From: TONY PHEBEY [REDACTED]
Sent: 26 November 2019 09:22
To: Zac Denton <Zac.Denton@arun.gov.uk>
Cc: 'Wayne Newton' [REDACTED]
Subject: RE: EP/129/19/HH - Extension of Time

This email is regarding the proposed development at 15 Warren Crescent, East Preston. My Team Leader will be unable to review the proposal until the 20th of November, if you are able to agree an Extension of Time until this date, it would be appreciated.

1422/P02 B

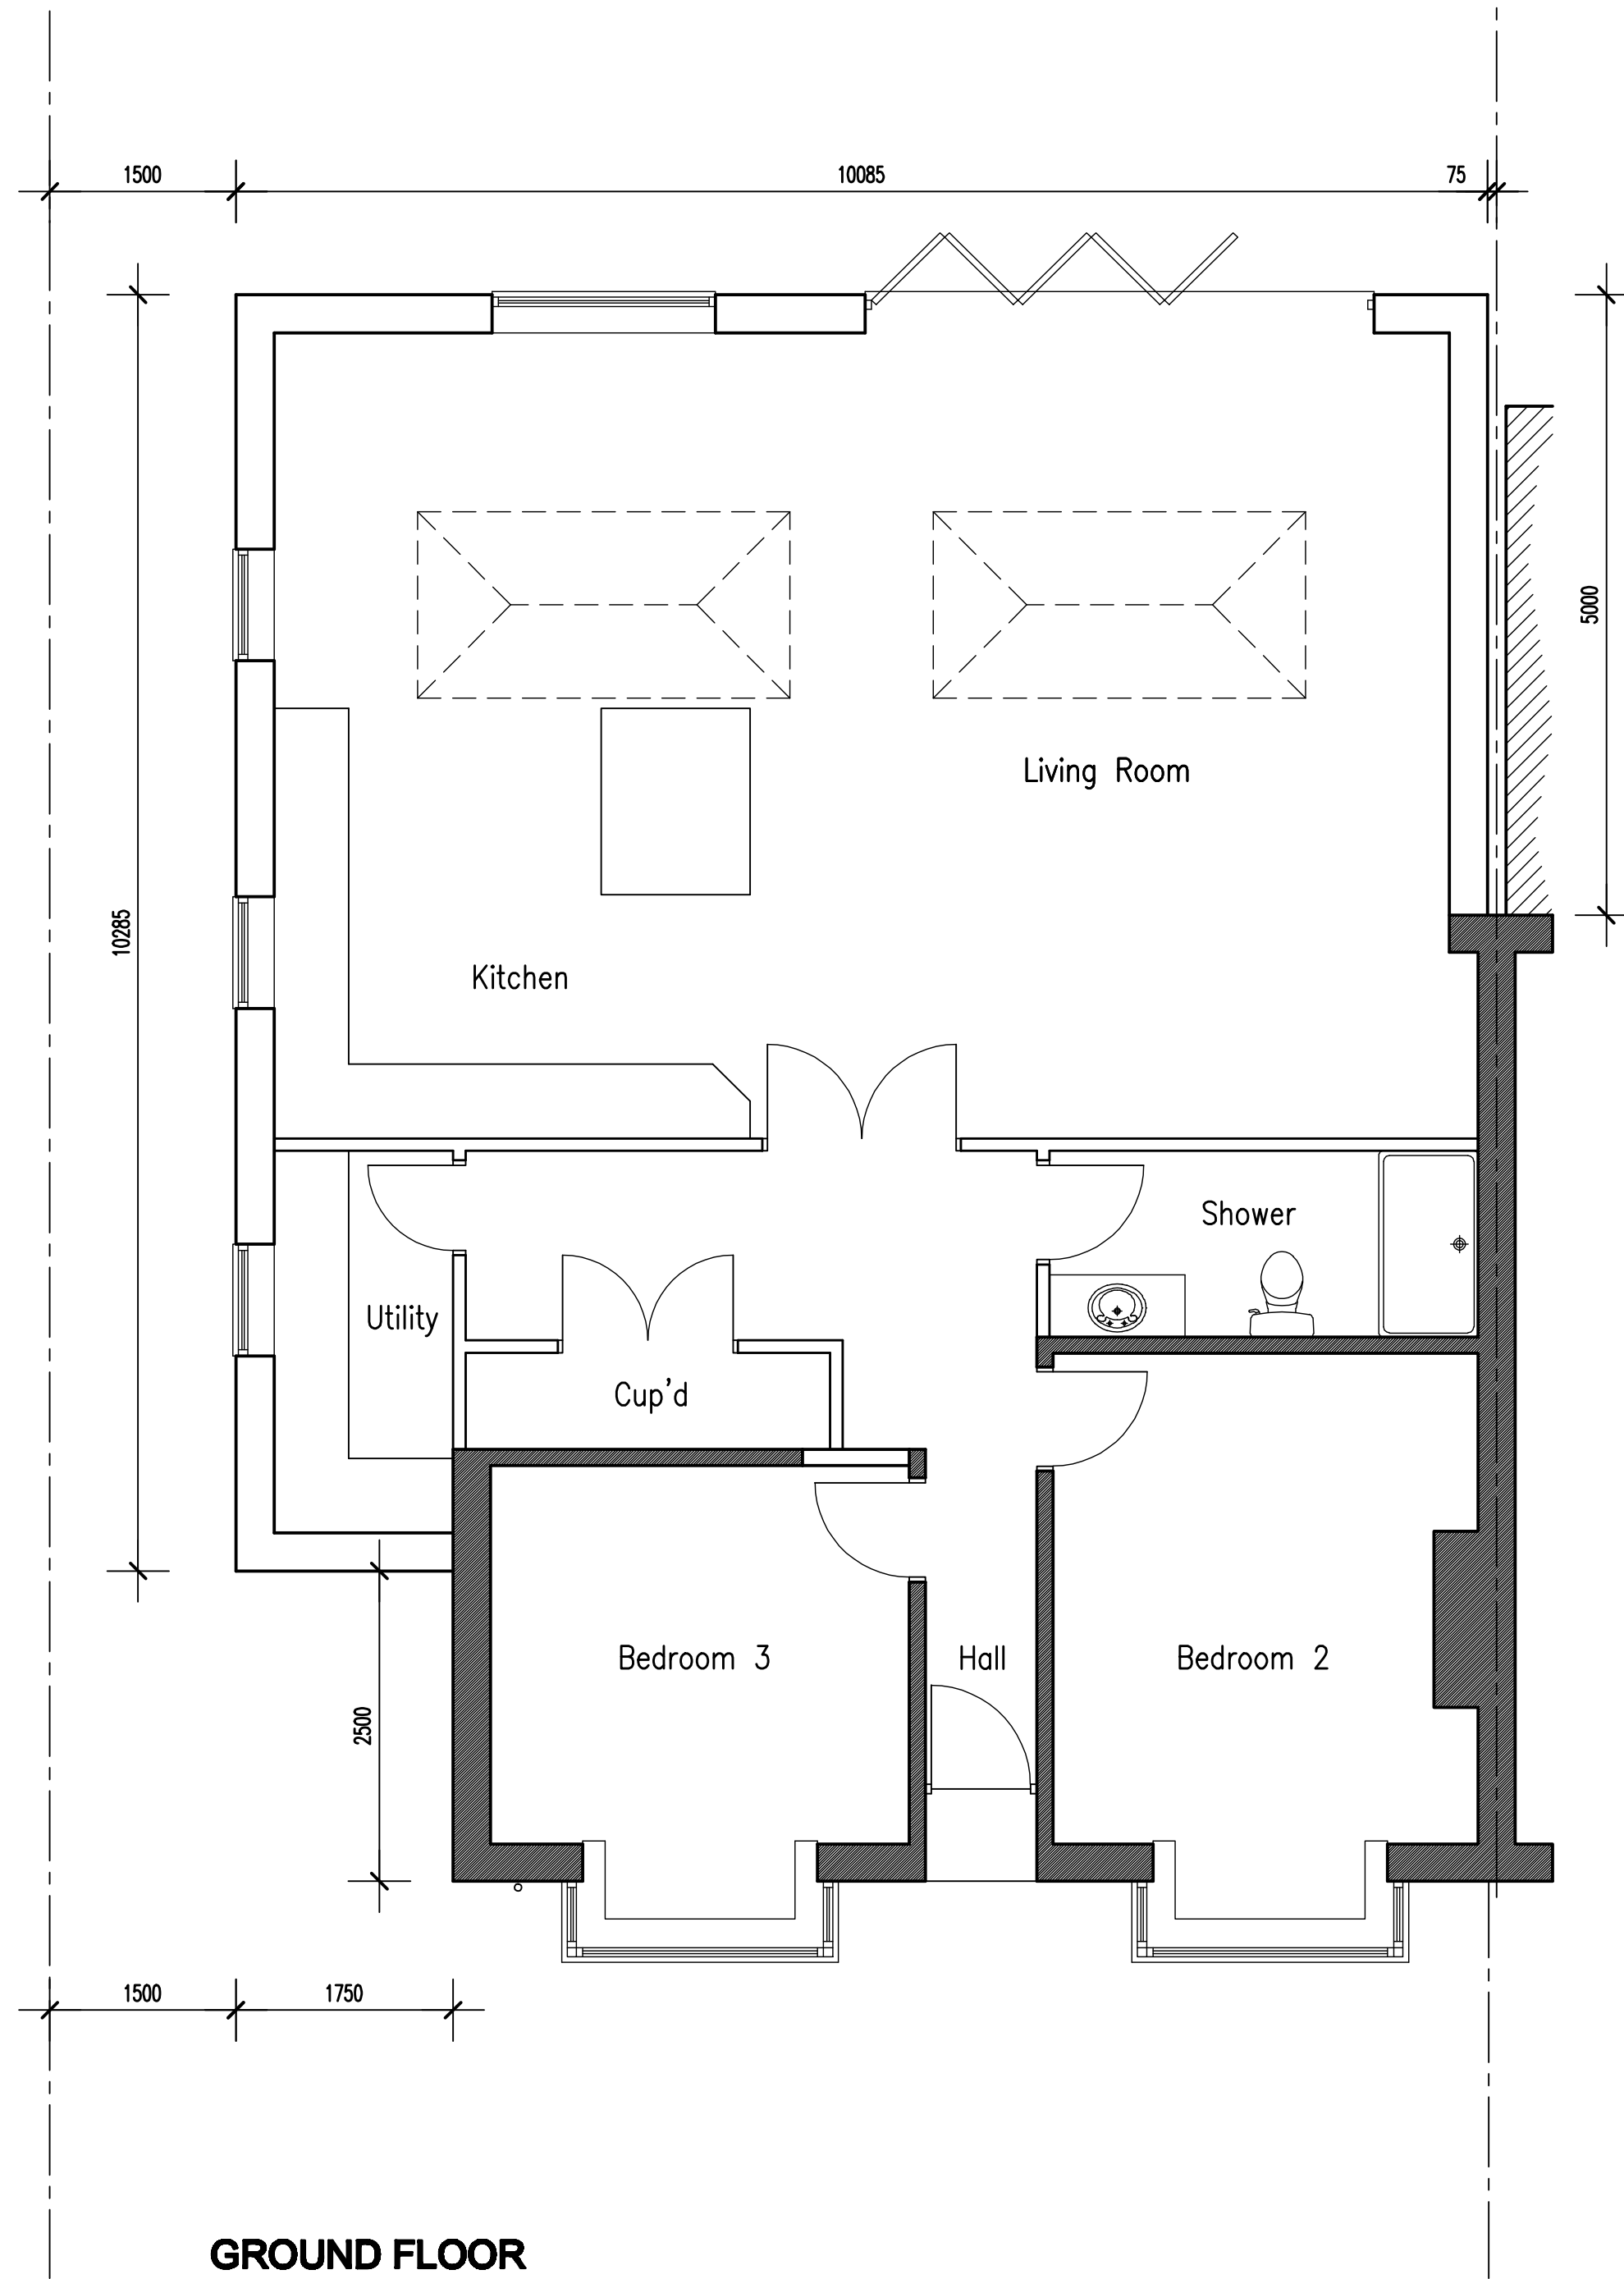
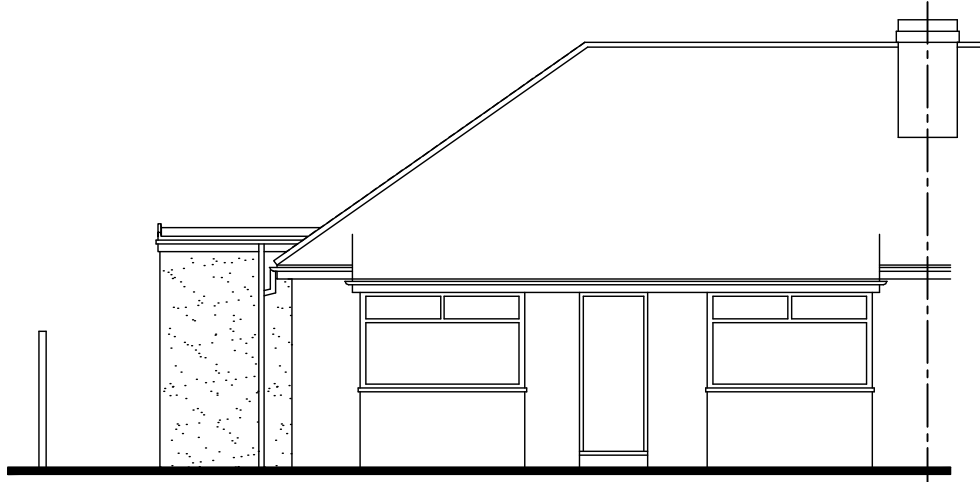
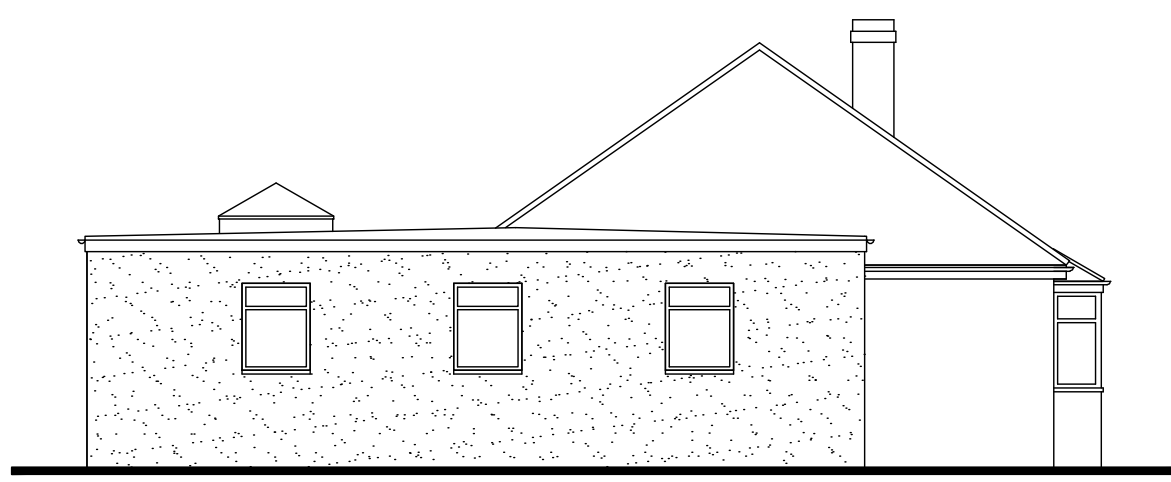
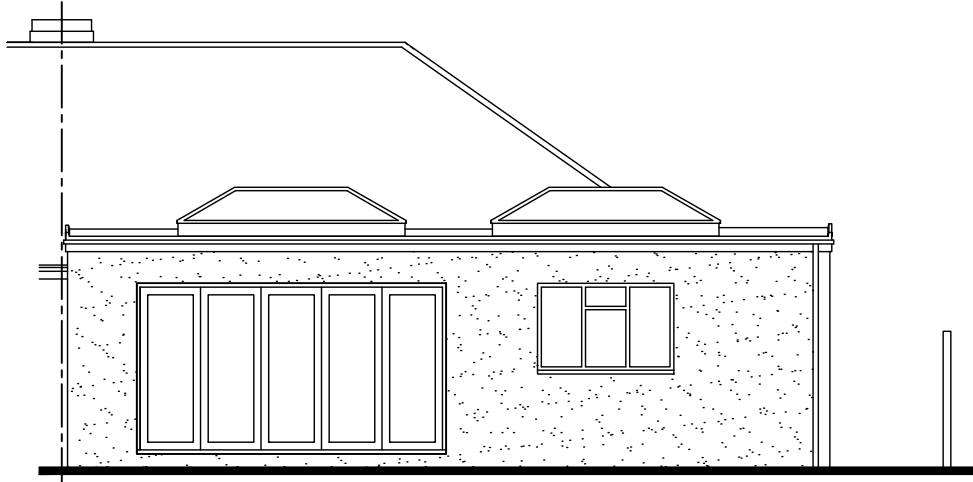
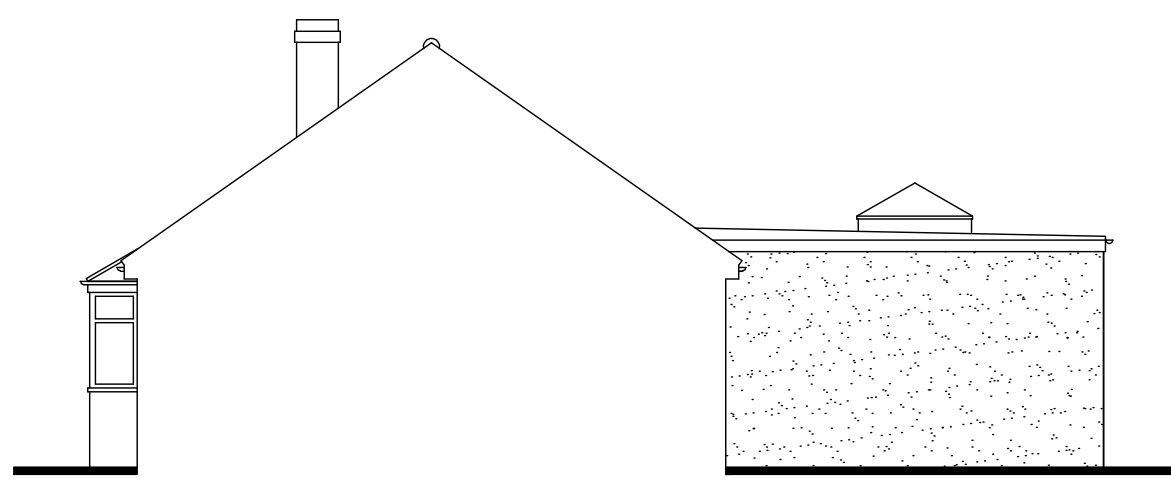
Unfortunately, the 0.5m reduction is not acceptable, if you are able to amend the drawings to be more inline with my previous comments, then this would be appreciated. Alternatively, if you have any other proposals, I am happy to consider these.

However, it is believed that amendments could be made in order to create a scheme that was looked upon more favourably by the LPA. These would be a 1m reduction in length of the rear extension, and a 2.5m reduction of the side element of the extension, away from the street scene.

We have reduced the rear extension by 1 metre as requested however we have reduced the side extension by 0.5 metre in order to maintain the internal utility room. This setback provides a distance of 950mm from the existing frontage which is sufficient to make the new extension appear to be subordinate to the existing bungalow.
